File: SF15/20035
Job ID No: DOC16/250393
Your Ref: SSD7056

RE: Response to Submissions for Remediation, Restoration and Adaptive Re-Use of Campbell's Stores, 7-27 Circular Quay West, The Rocks (SSD 7056)

Pauline McKenzie
Acting Executive Director, Heritage Division
Office of Environment and Heritage
As Delegate of the NSW Heritage Council
9 June 2016

03 HICKSON ROAD / SOUTH-WEST ELEVATION
SCALE 1:50

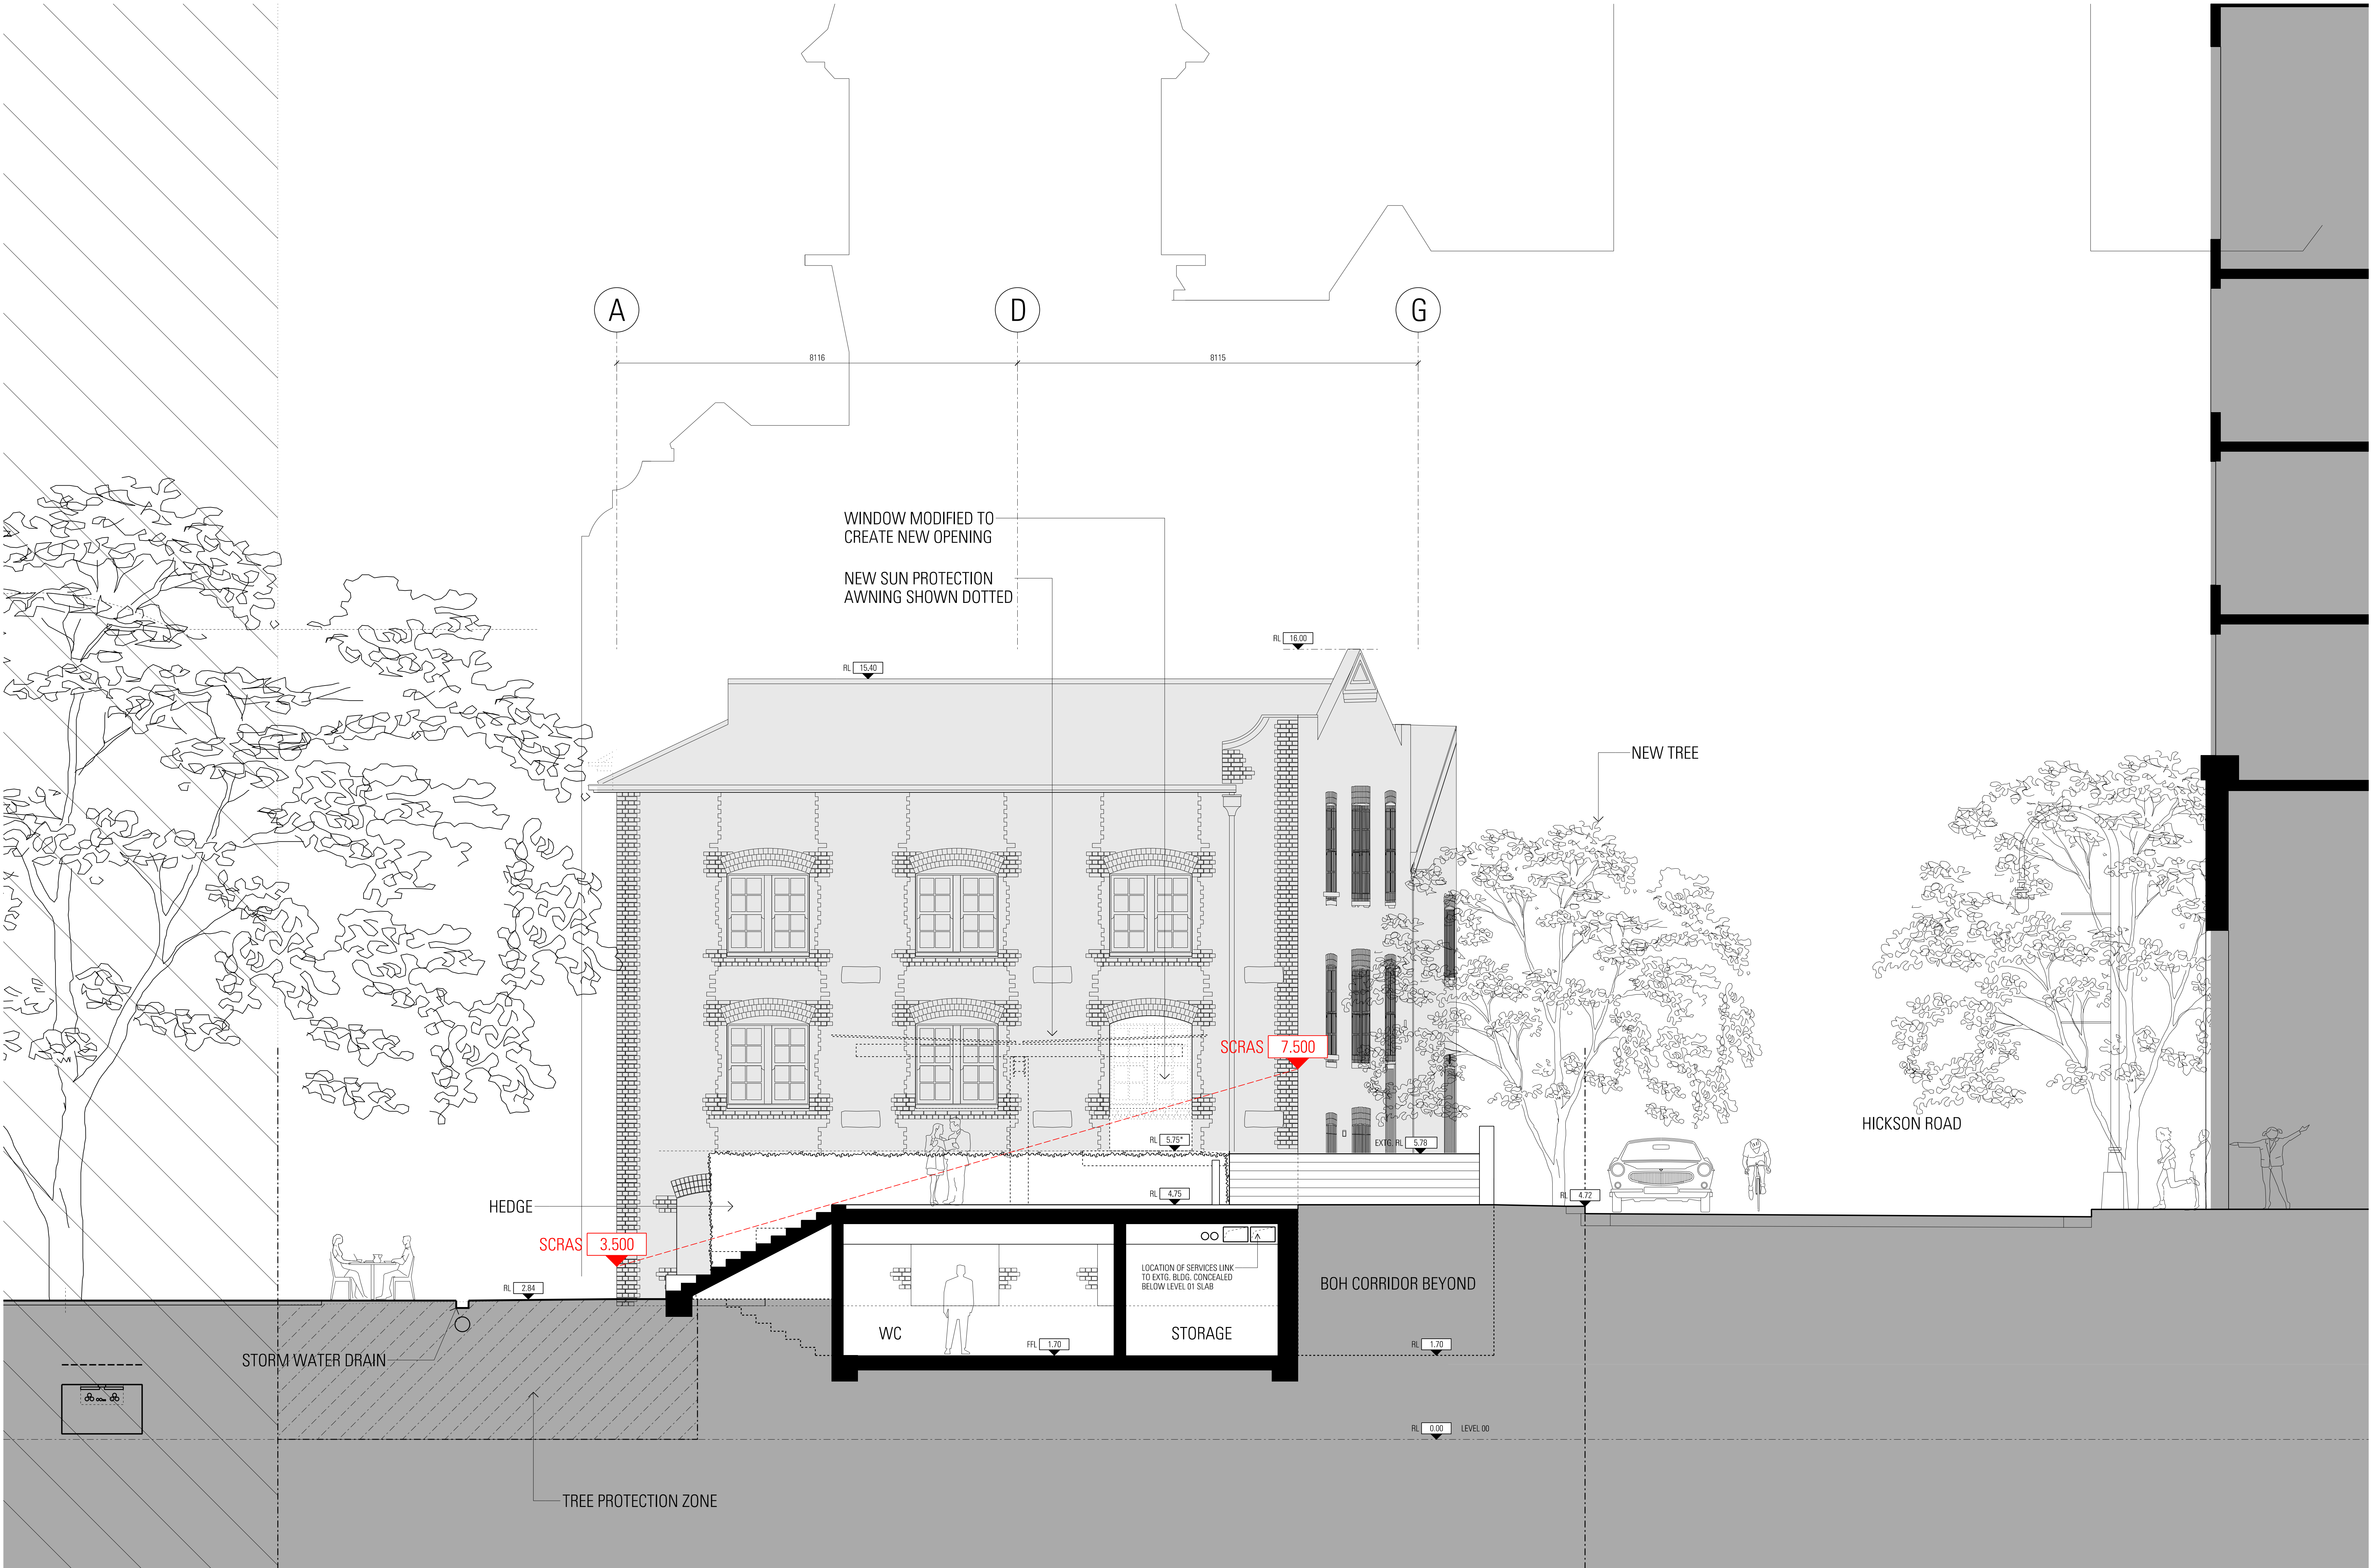
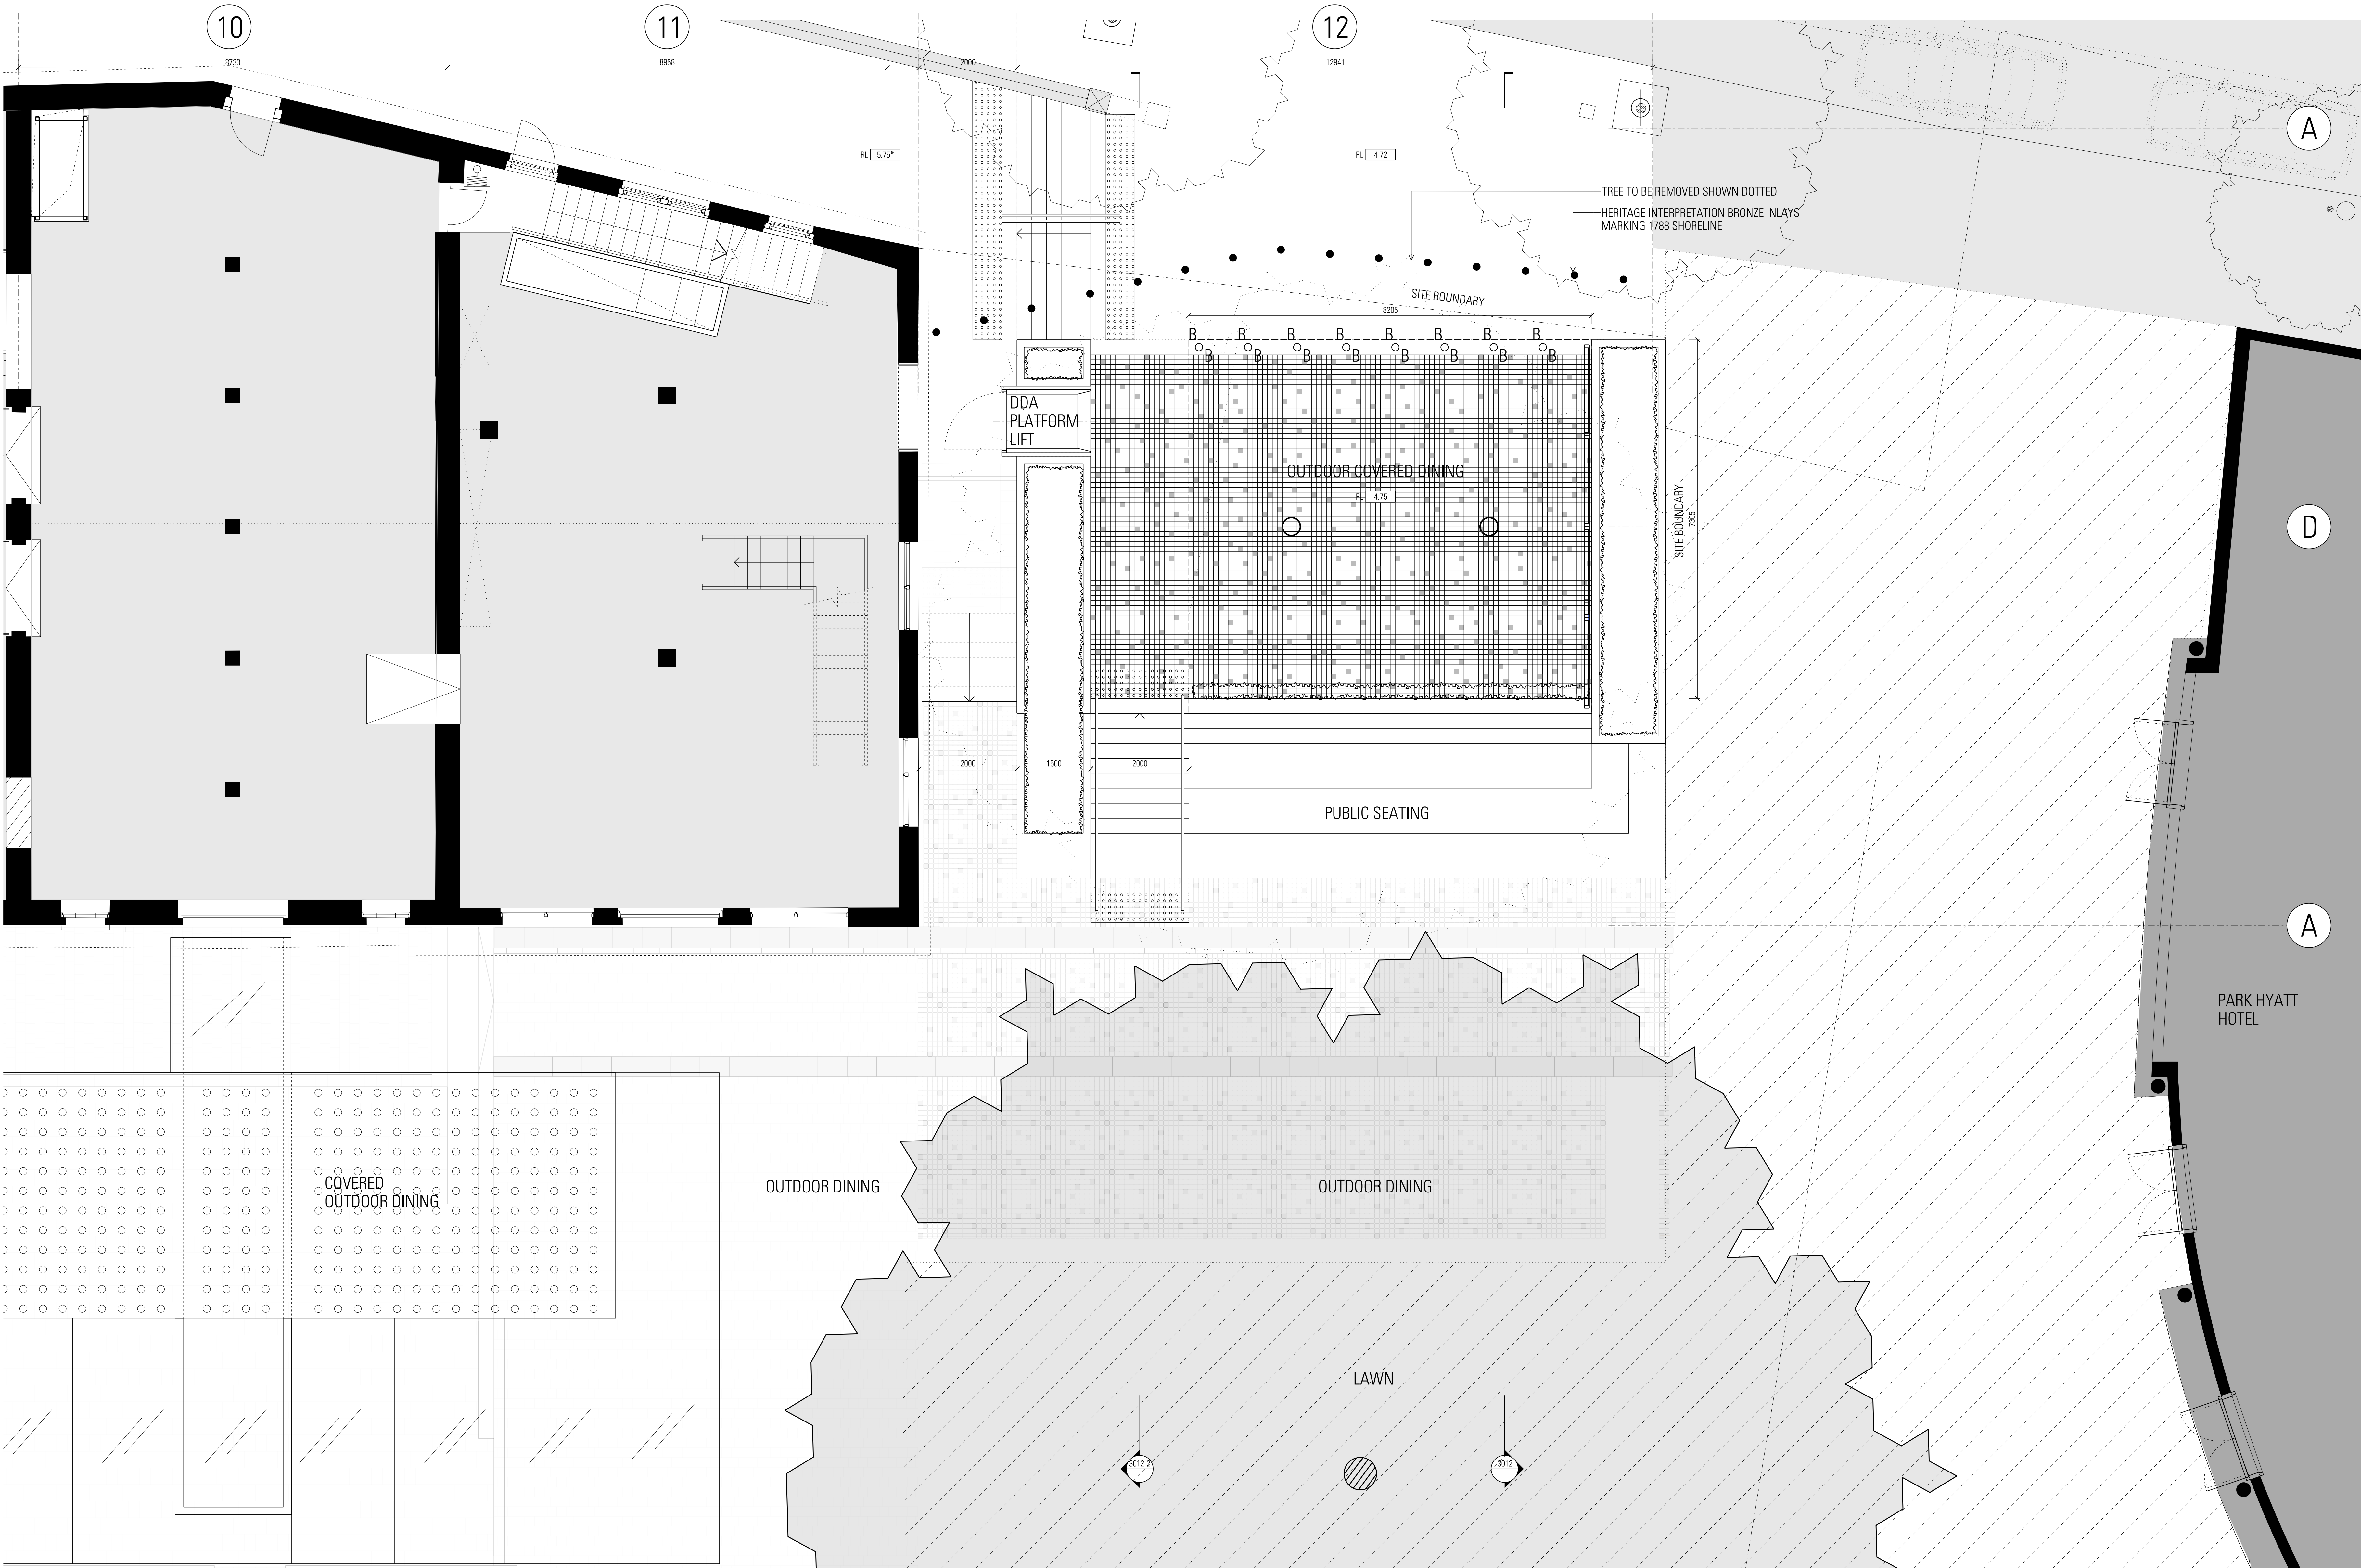
Whilst the revised design of openings to the Hickson Road façade still proposes three openings, they have been reduced in width, and the contemporary awnings redesigned to be compatible with the architectural character of Campbell's Stores. The three entrances are supported in that they provide for functionality of the public and private internal configuration of the building, which will have a heritage benefit through reducing the extent of alterations required for future tenancies.
